STATE OF WASHINGTON
DEPARTMENT OF ECOLOGY

November 25, 2019

Re: SV-19-00001, SE-19-00011

Thank you for the opportunity to comment during the optional determination of nonsignificance process for the construction of the Thayer Bridge. We have reviewed the documents and have the following comments.

SEPTEMBER 2019
THAYER PROPERTY DEVELOPMENT
FOR SINGLE FAMILY RESIDENCE
ACCESS BRIDGE SITE PLAN
DRAWING 4

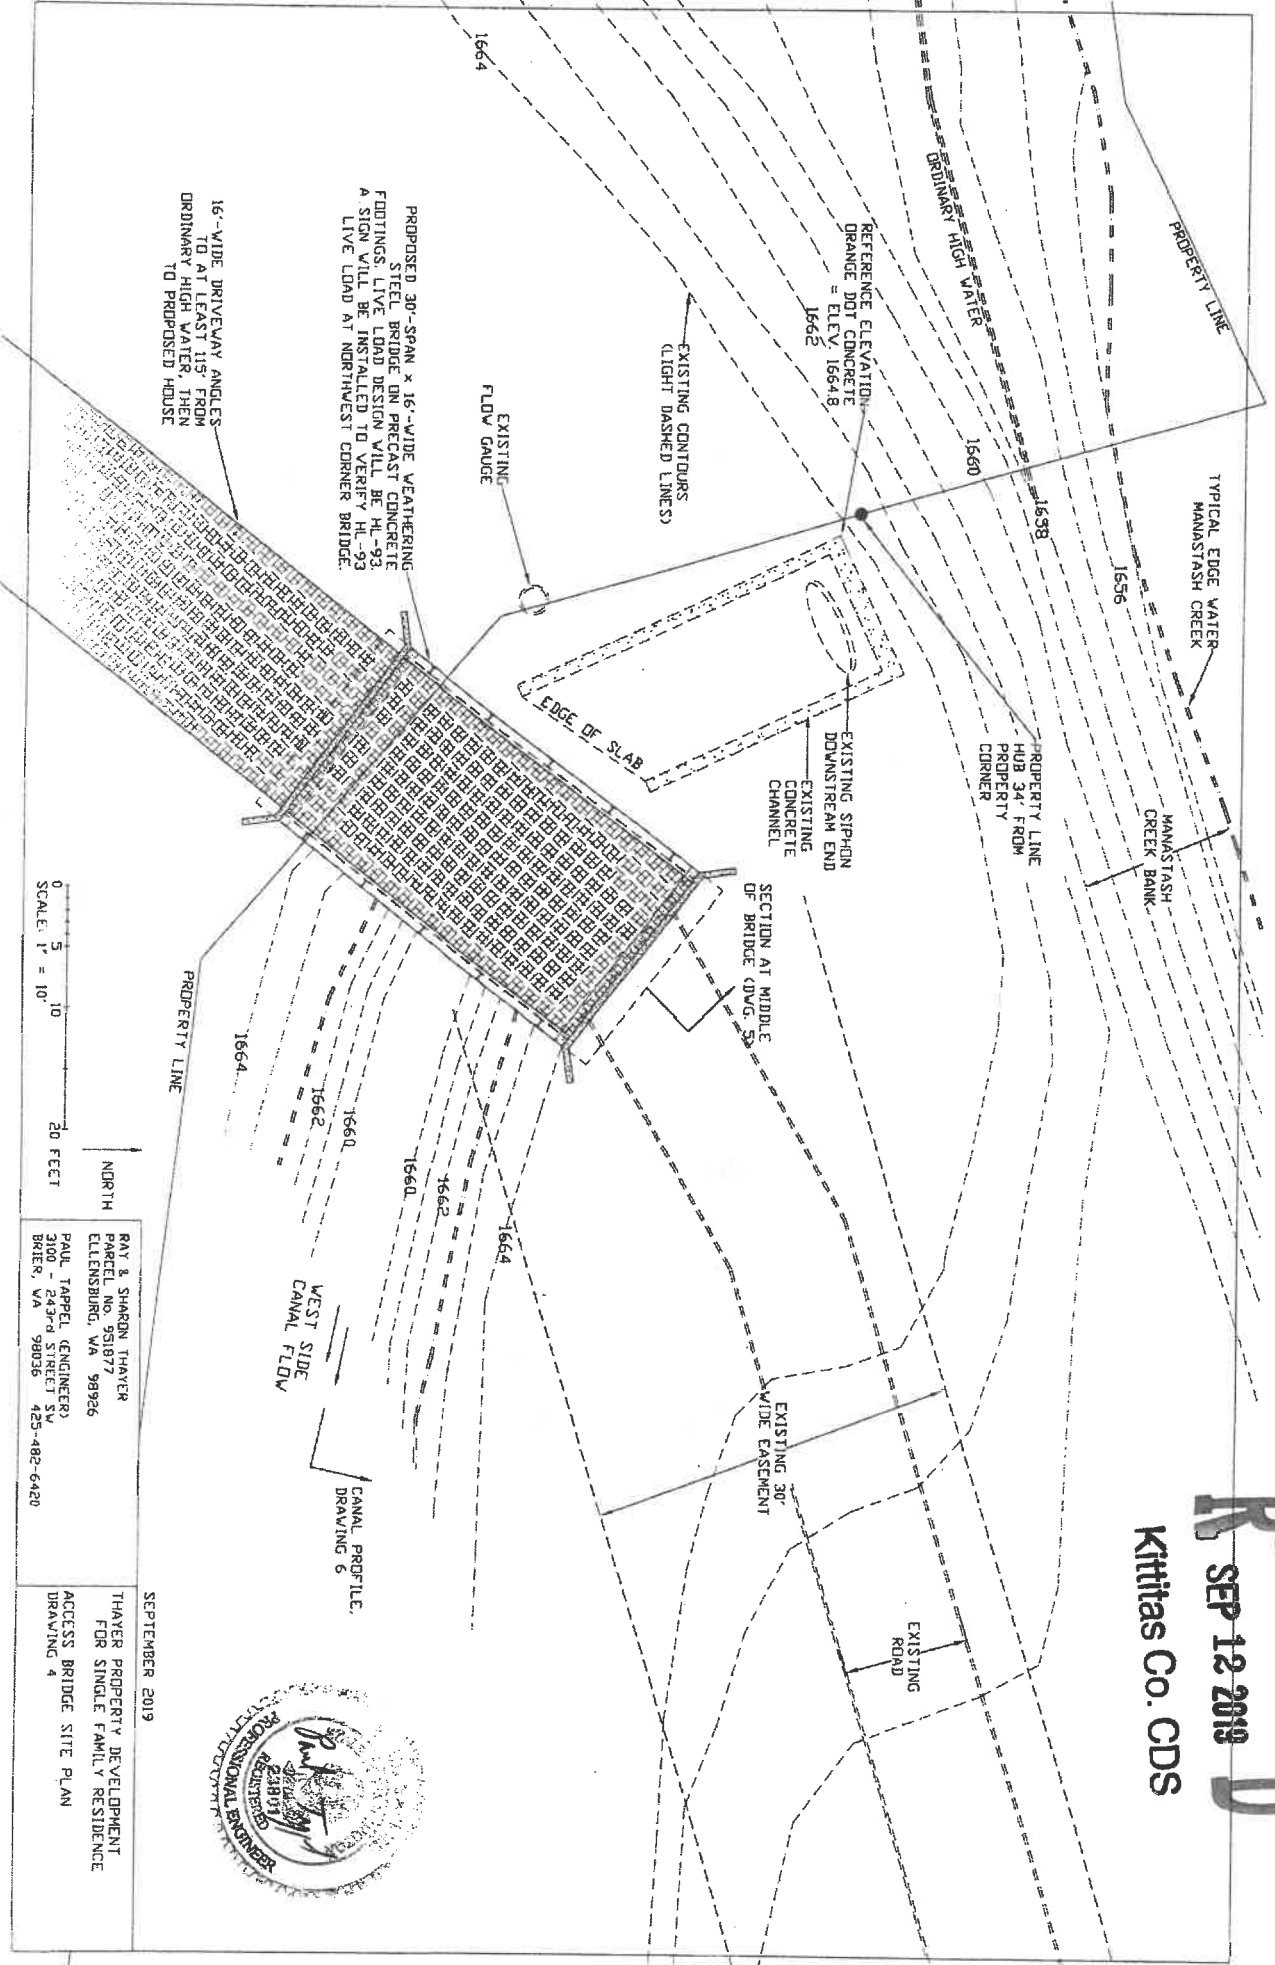
The SEPA checklist does not state when the project will be completed. It will be preferable to replace the bridge over West Side Canal outside of the irrigation season, to avoid as much sediment pollution as possible.
